<b>Reference No:</b>	2026/70/90162/W
<b>Site Address:</b>	Hinchliffe Mill, Water Street, Holmbridge, Holmfirth, HD9 2NX
<b>Description:</b>	Variation of condition 2 (plans and specifications) of previous permission 2021/90800 for redevelopment and change of use of former mill site to form 19 residential units (within a conservation area)
<b>Recommending Officer:</b>	Victor Grayson

**DECISION – Section 73 Variation of Condition – Approve**

## Officer Report

Drawn DRH
Date June 2025
Scales 1:100 @ A2
Drawing No. 2559 - 0306 - P04

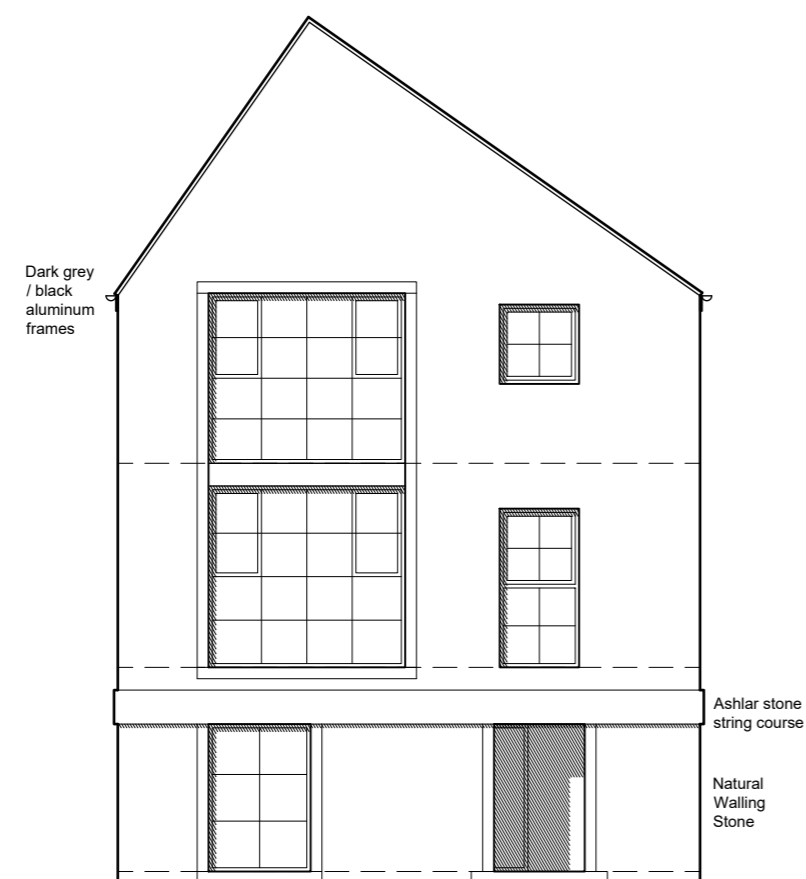
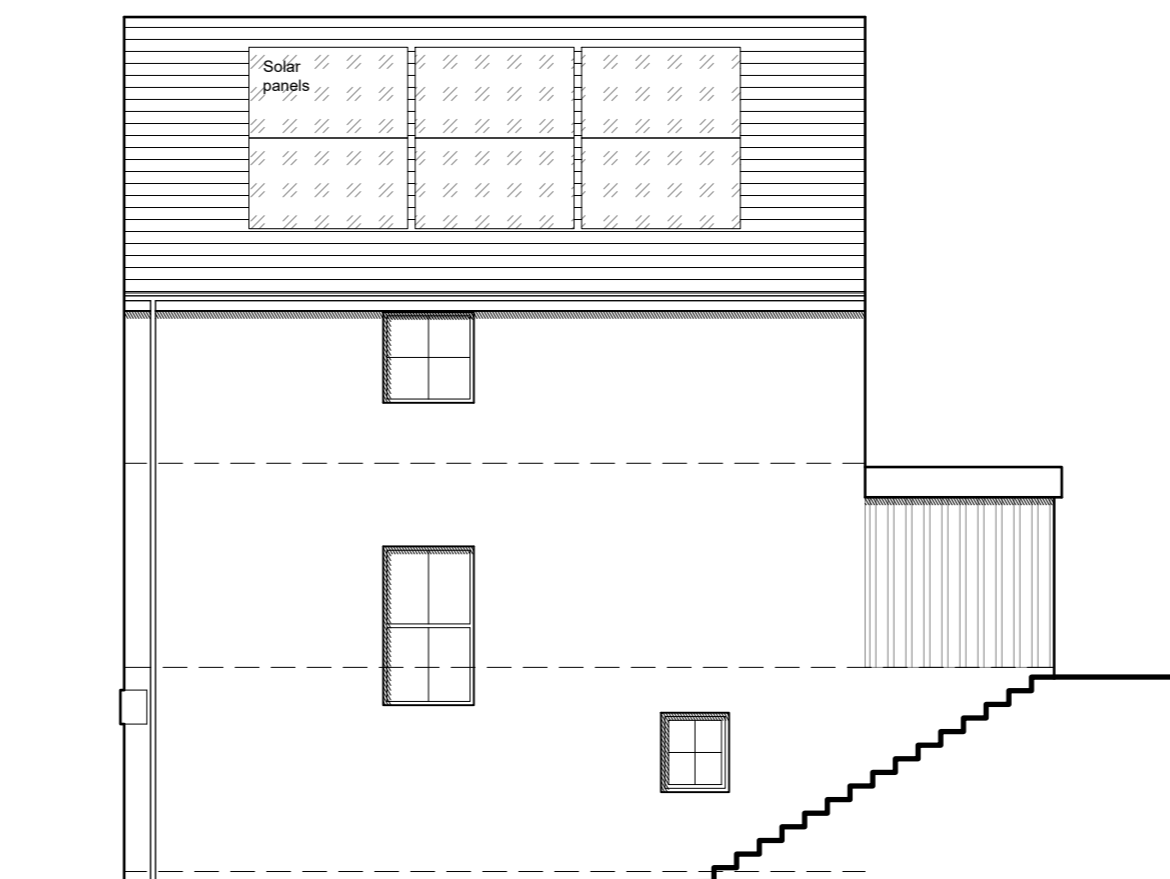
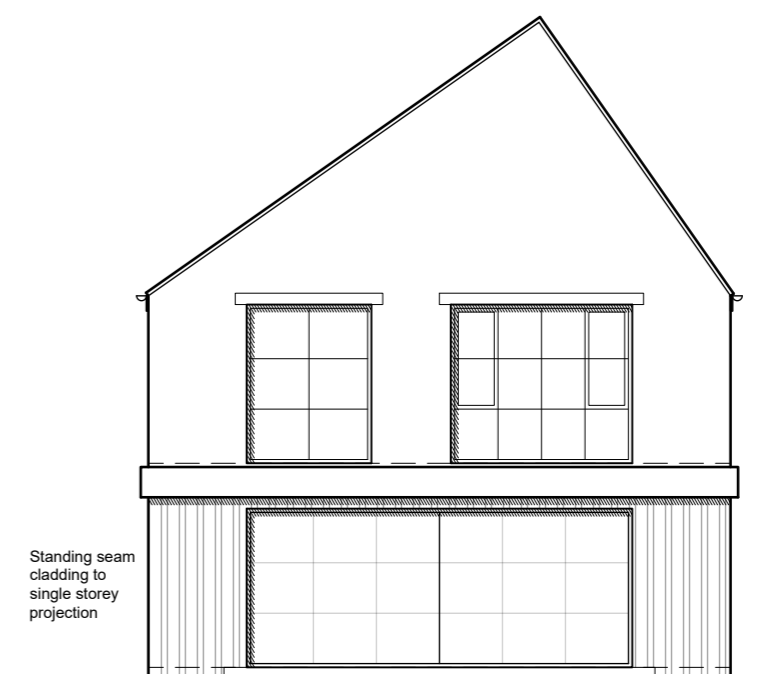
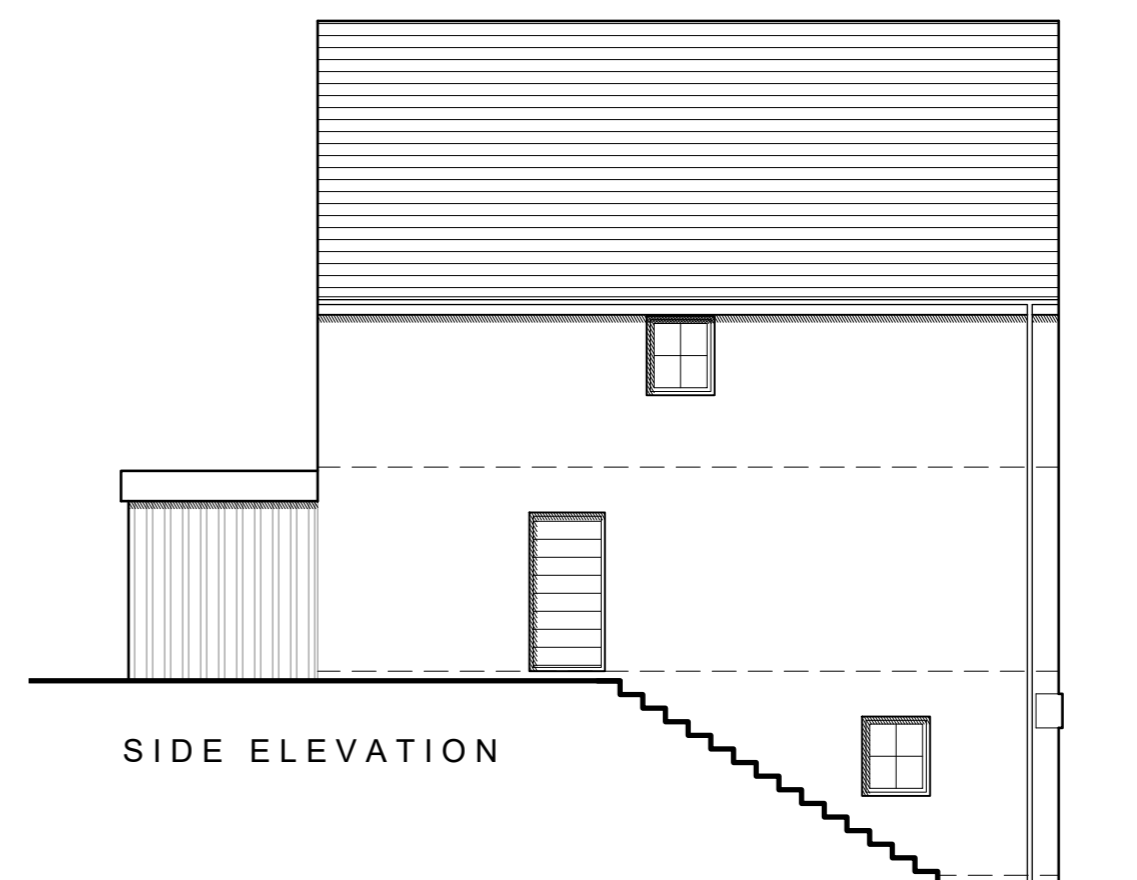
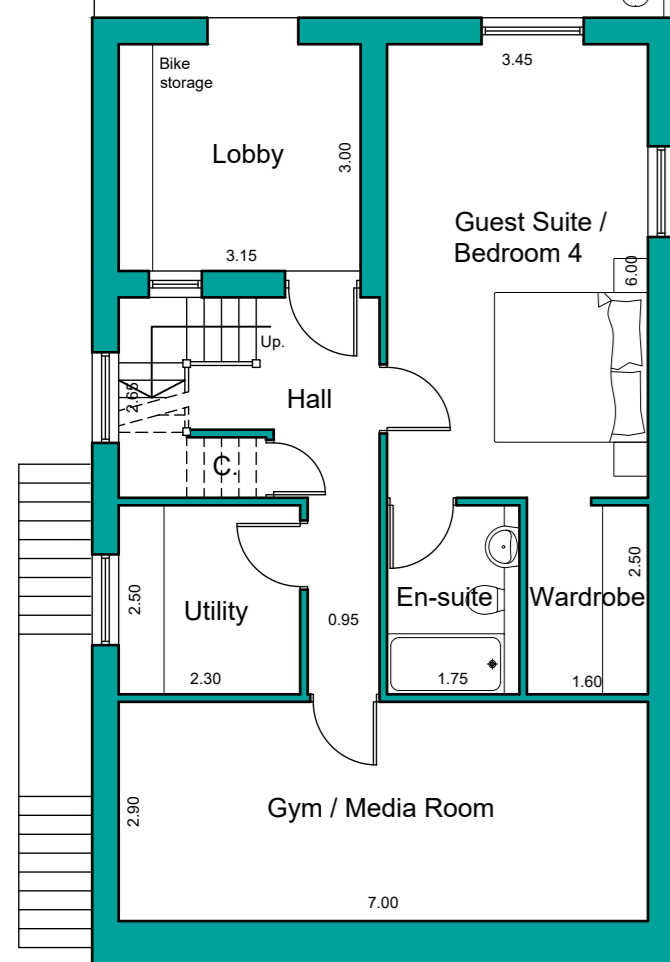
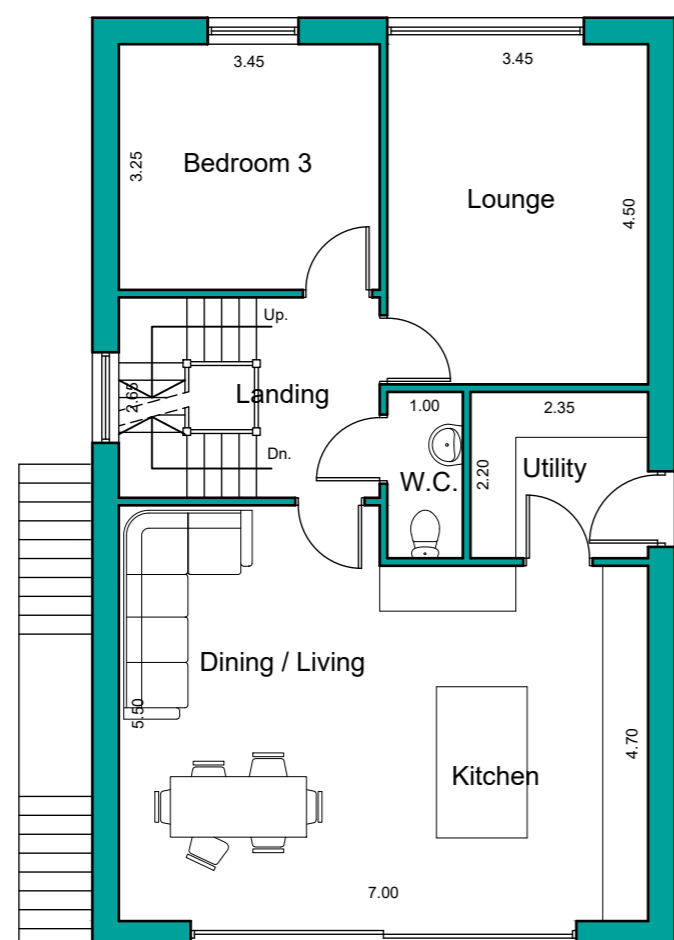
Approved drawing 3372 (0-) 403 rev E showed one house type for units 10, 11, 12, 13, 14 and 15, while approved drawing 3372 (0-) 404 rev D showed a similar (but slightly different) house type for unit 16. In the current submission, the applicant proposes a house type A for units 12 and 14 (illustrated in drawing 2559-0304 rev P03), house type B for units 10, 11 and 13 (illustrated in drawing 2559-0305 rev P04), and house type C for units 15 and 16 (illustrated in drawing 2559-0306 rev P04). Again, there is a great deal of similarity between the house types proposed within this group of seven dwellings.

Regarding the proposed changes, the loss of the previously-approved projecting/cantilevered elements is regrettable in some respects, as it would reduce the elevational relief and visual interest of the elevations. However, the simplified elevations now proposed are still considered appropriate for this site and its context, and approval of them would have been recommended had they been proposed under application 2021/90800.

The other fenestration changes to units 10 to 16, the introduction of an ashlar stone string course, and the proposed replacement of recessed external porches with internal entrance lobbies are considered acceptable in aesthetic terms.

The expanded footprints and floorplates of units 10 to 16 (partly achieved by what the submitted Planning Statement refers to as “single storey flat roof extensions”) raise no concerns, nor do the proposed amendments to the internal layouts of these units.

For units 10 to 16, new materials would be introduced under the current application, namely black standing seam profile cladding (to the above-mentioned extensions) and a corrugated black roofing material (for the garages). Materials coloured black have previously been proposed elsewhere in the development, and this colour is generally considered acceptable for this

Drawn DRH
Date June 2025
Scales 1:100 @ A2
Drawing No. 2559 - 0305 - P04

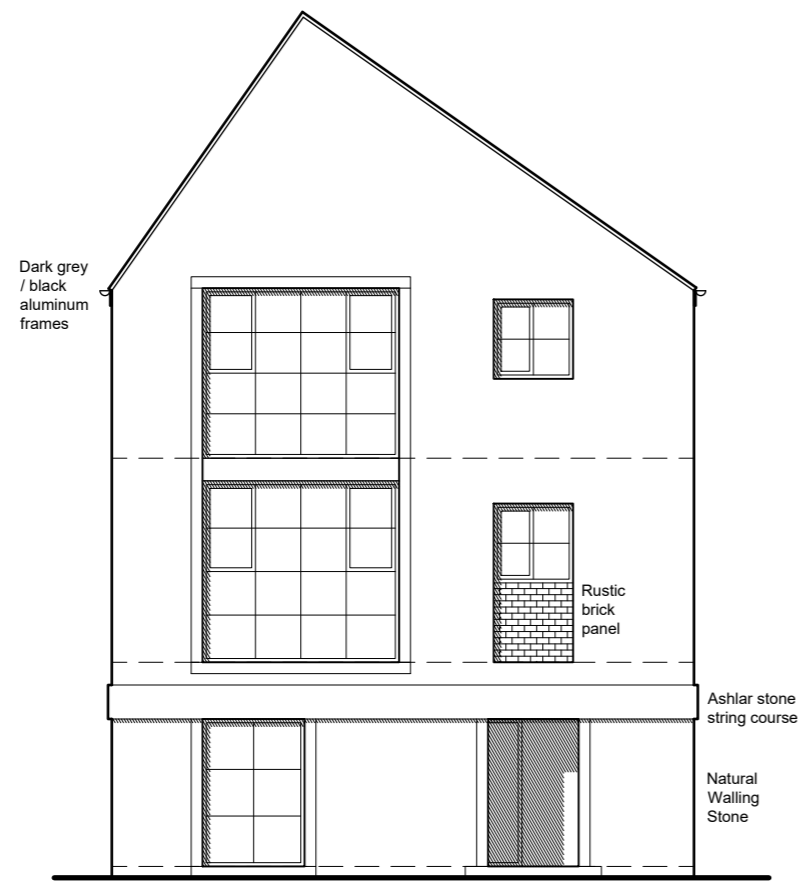
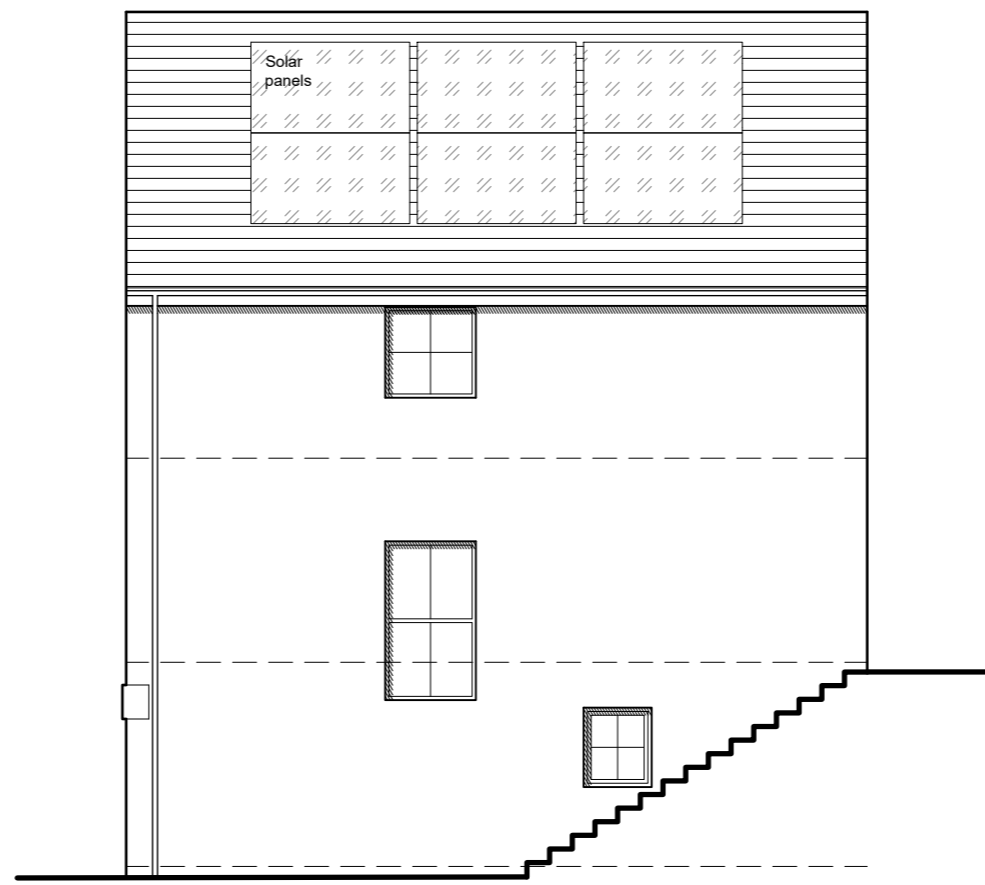
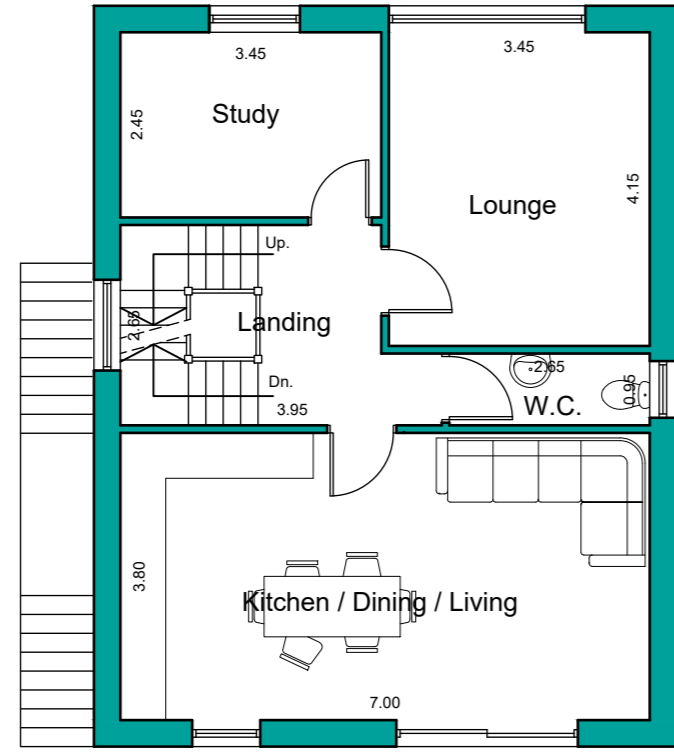
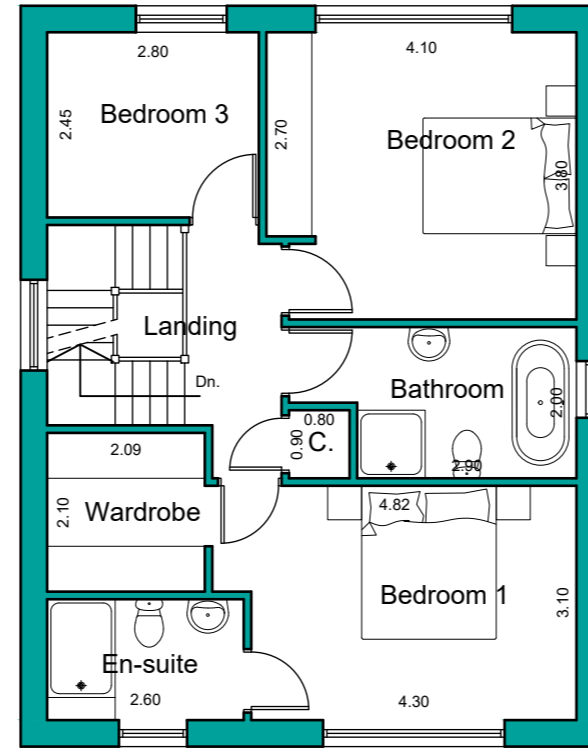
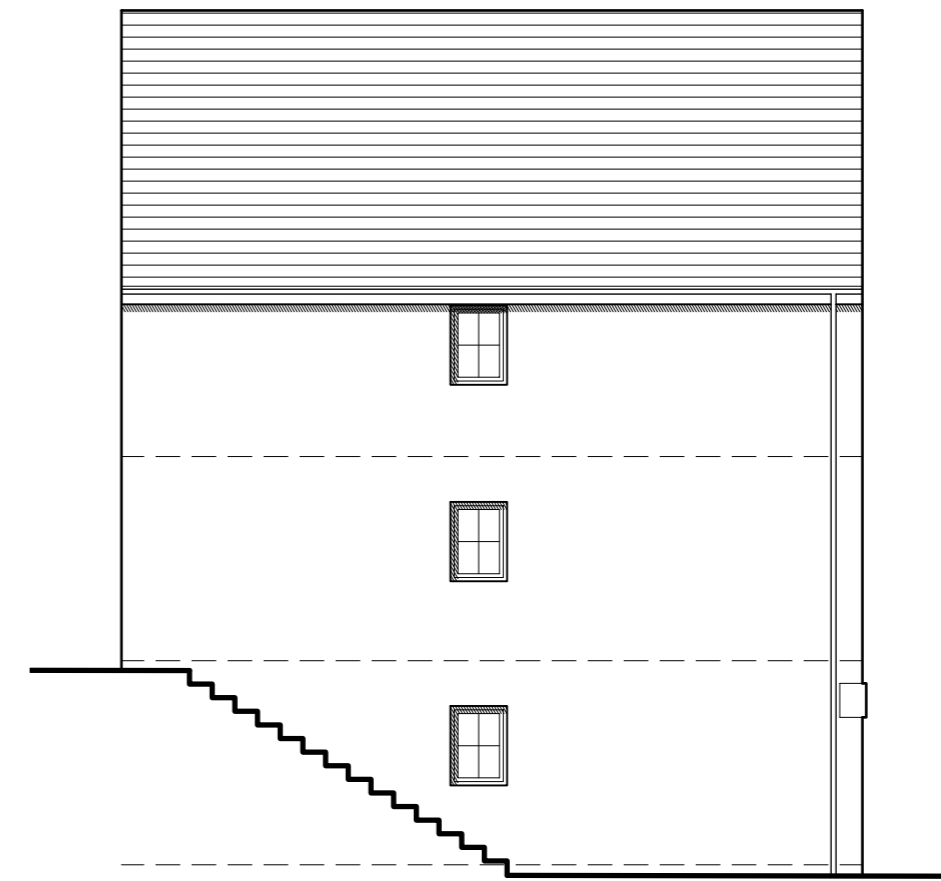
The proposed introduction of “rustic brick” panels to some of the window apertures (in house types A and B) is considered acceptable in principle (of note, a similar design feature has been included in two major developments on Manchester Road), subject to the proposed materials being considered at conditions stage.
